CITY OF ALBUQUERQUE

RE: **Memorial Park Anderson Heights Unit 4**
Engineer's Stamp Date: 1/22/2018
Hydrology File: N08D006F1

Based on the information provided in the submittal received on 1/22/2018 the above-referenced Grading and Drainage Plan cannot be approved for Grading Permit until the following comments are addressed.

OVERALL GRADING & DRAINAGE PLAN

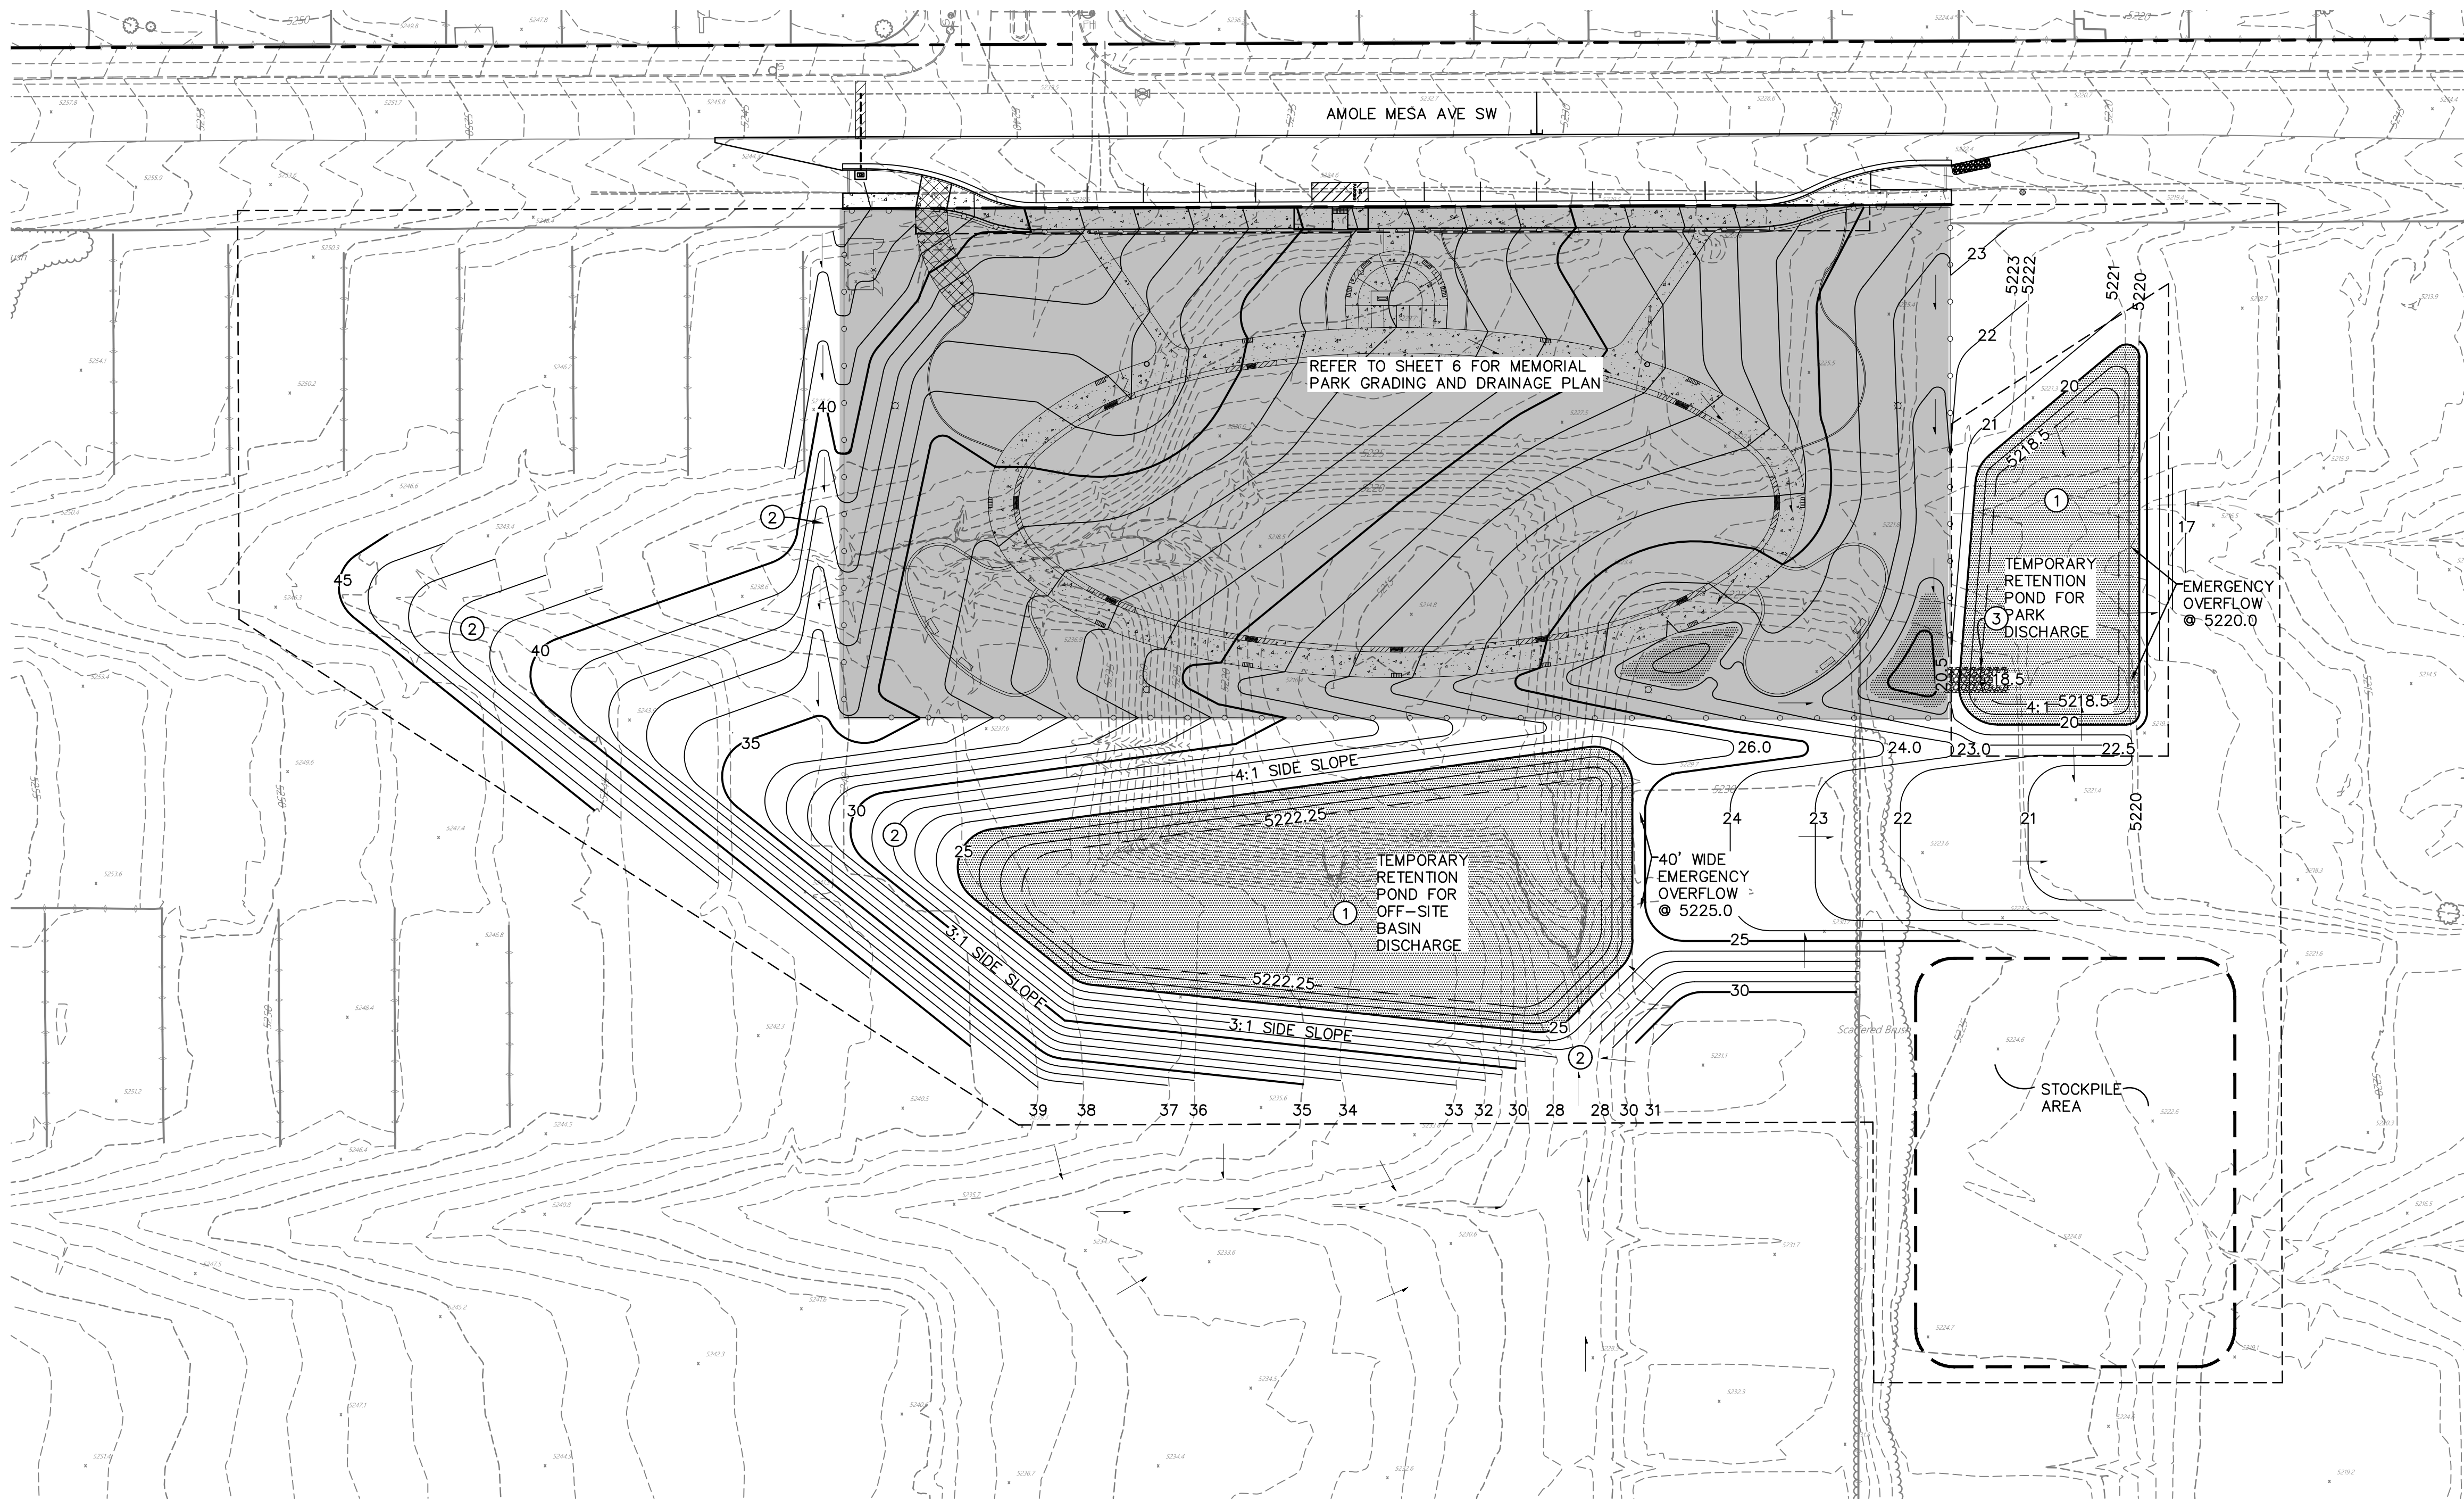
1. A Public Drainage Easement must be recorded to contain the east temporary retention pond.
2. A new Drainage Covenant must be recorded for the new pond location. The previous covenant can be released if the new covenant includes all of the ponds shown on the previous covenant.
3. Provide a letter of permission from the owner of the neighboring property for the grading on their property.
